Application No: WA/93/20/PL  
Site Address: Land East of Tye Lane Walberton BN18 0LU  
Description of works: Alternative vehicular access off Tye Lane & emergency access off Avisford Park Road, along with minor highway works following WA/95/18/RES. This site is in CIL Zone 2 (Zero Rated) as other development.

Thank you for your internet representation made on 14th May 2021 which has been recorded as an objection with the comments as follows:

Appendix B
Traffic Flow Diagrams

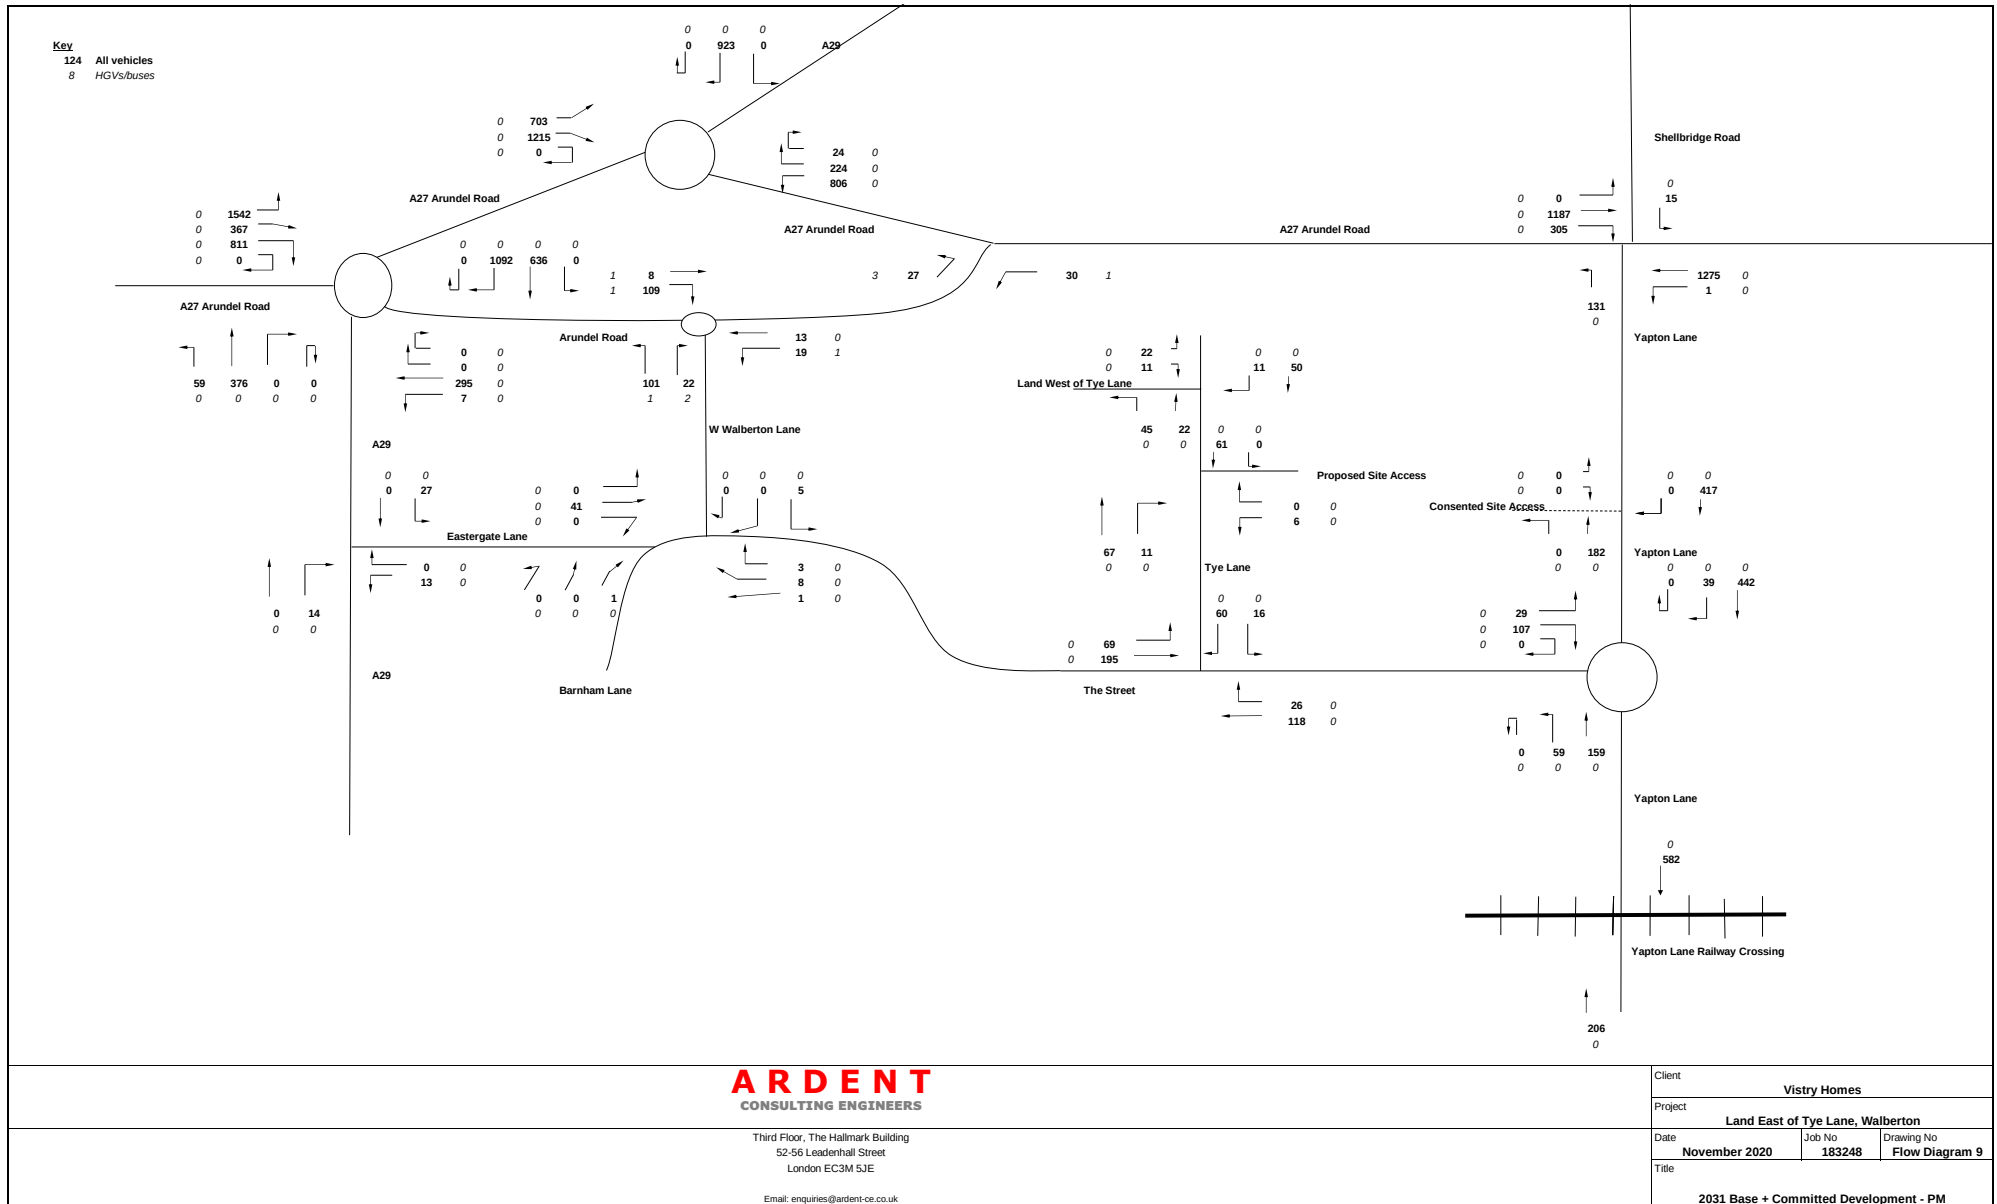
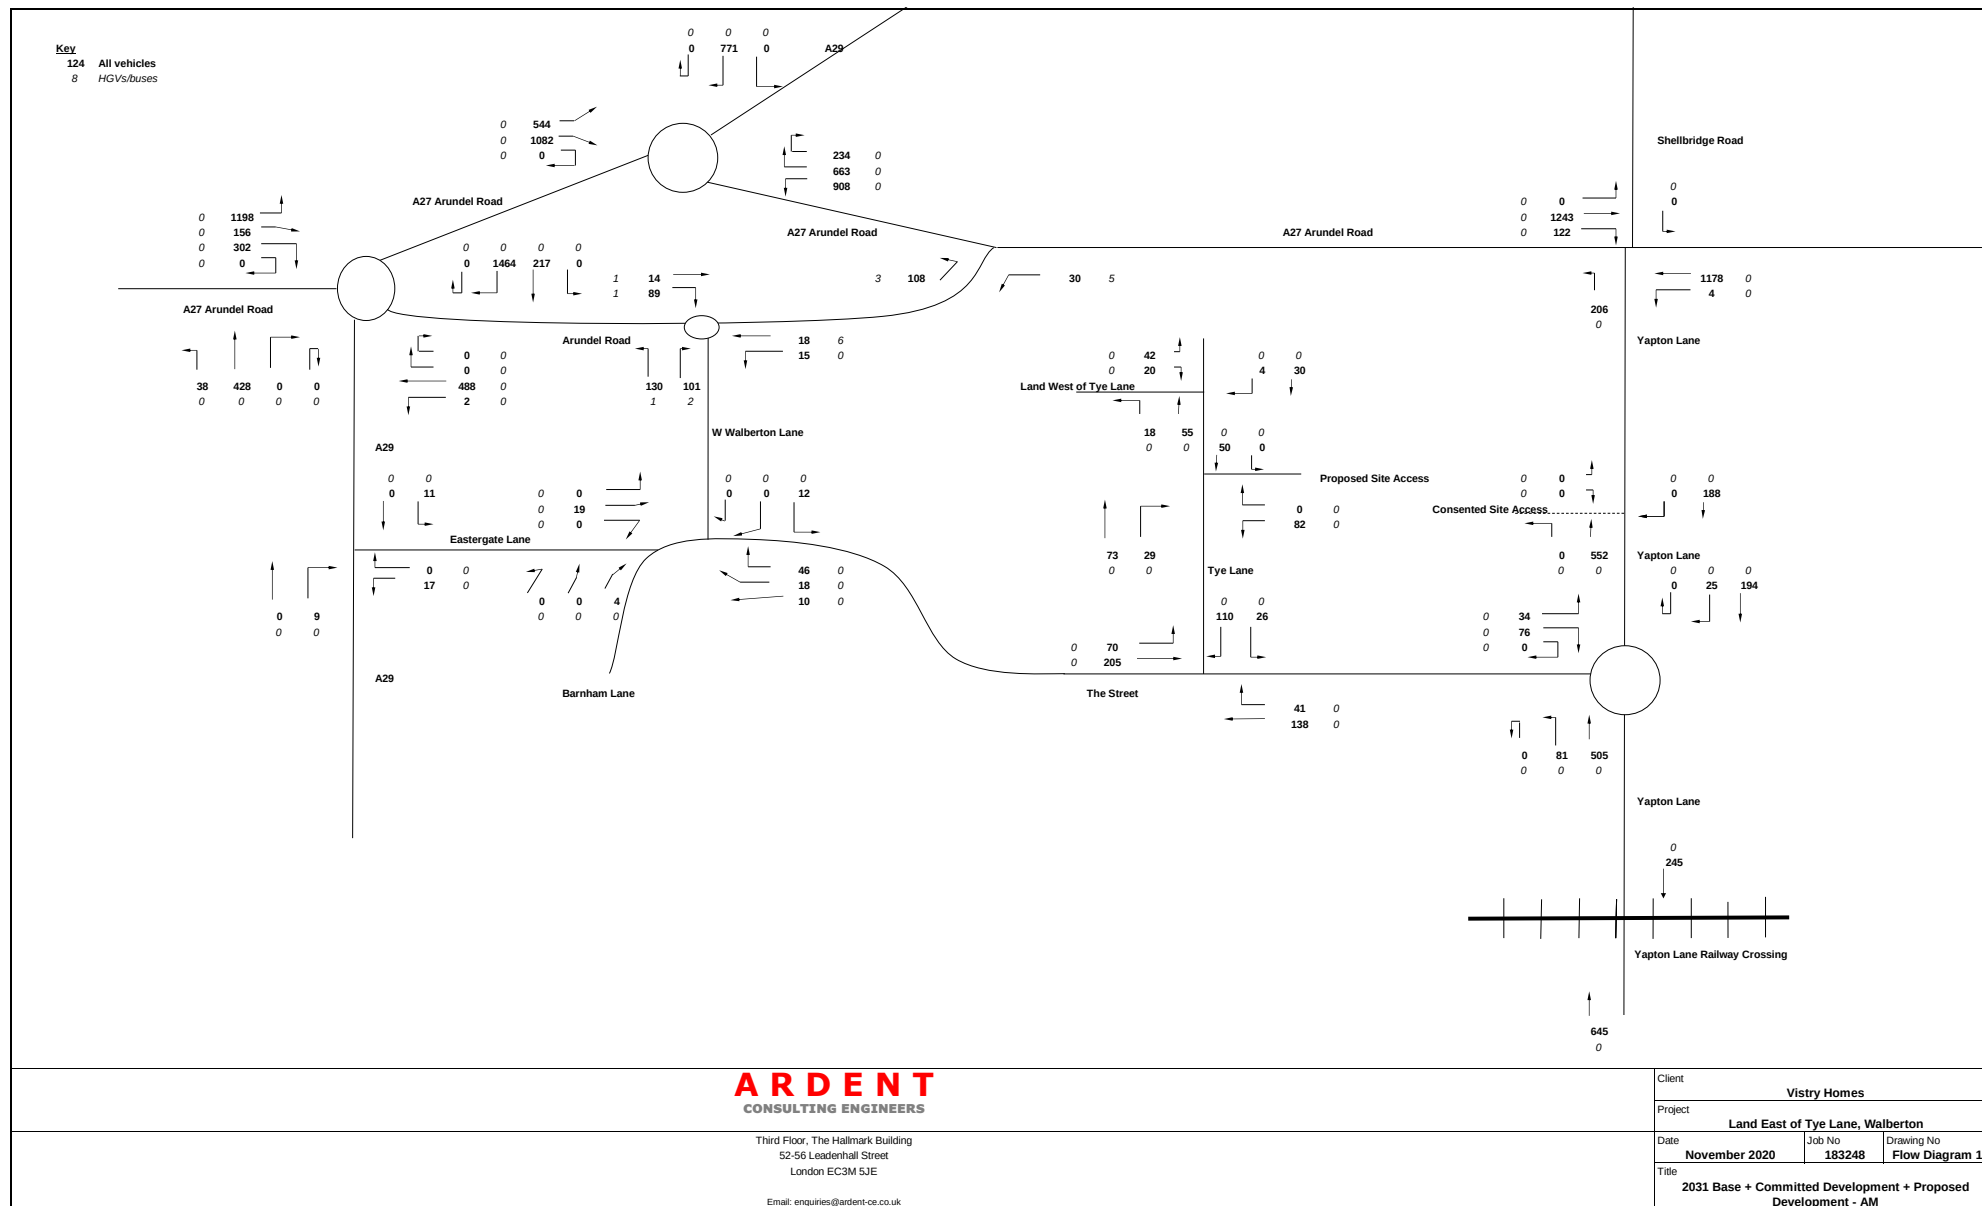
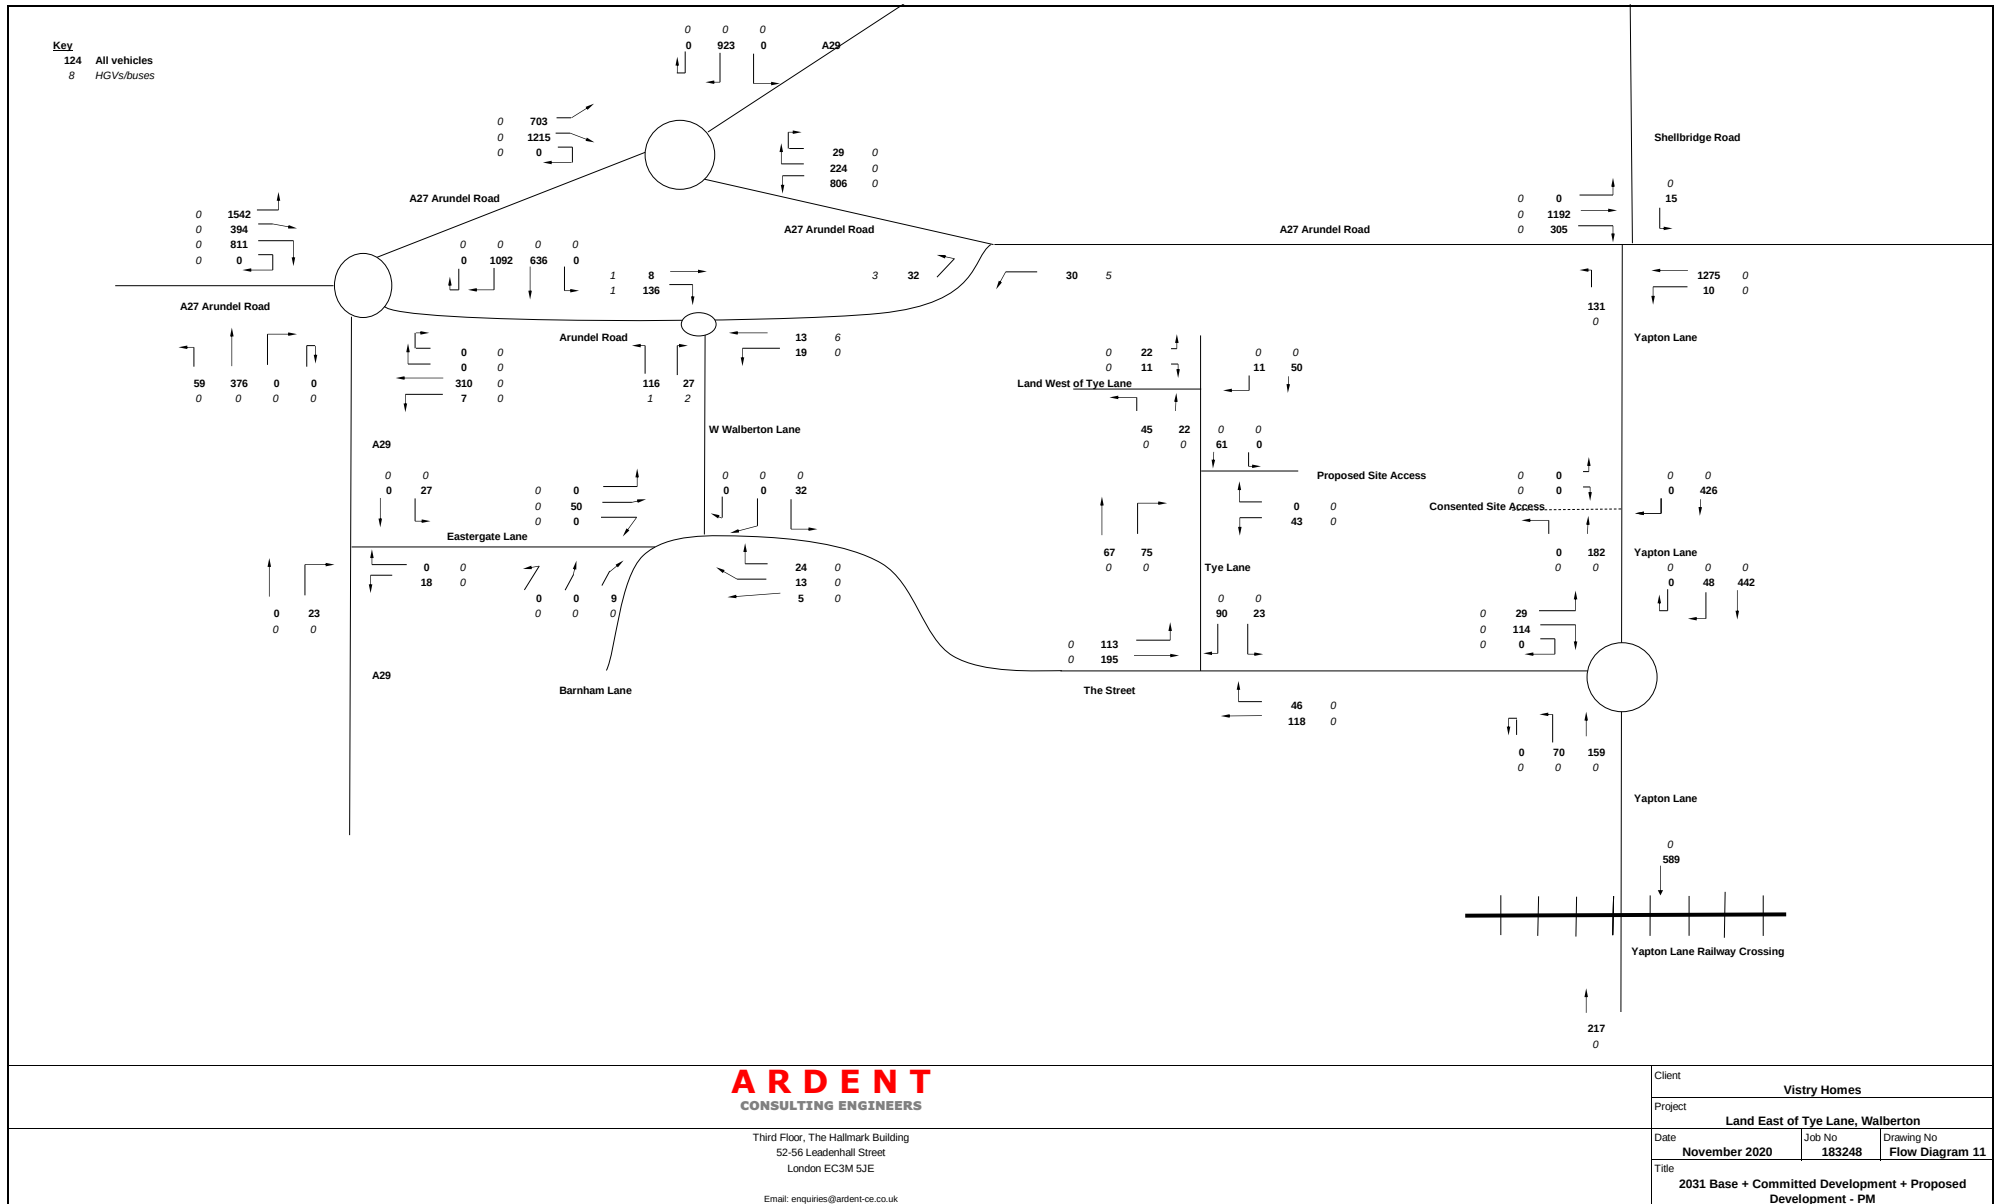
A number of Traffic Flow Diagrams are provided to illustrate changes in traffic flow patterns. However, they seem to have incorrect data. It is not clear whether the application is based on Tye Lane being open or closed at the A27.
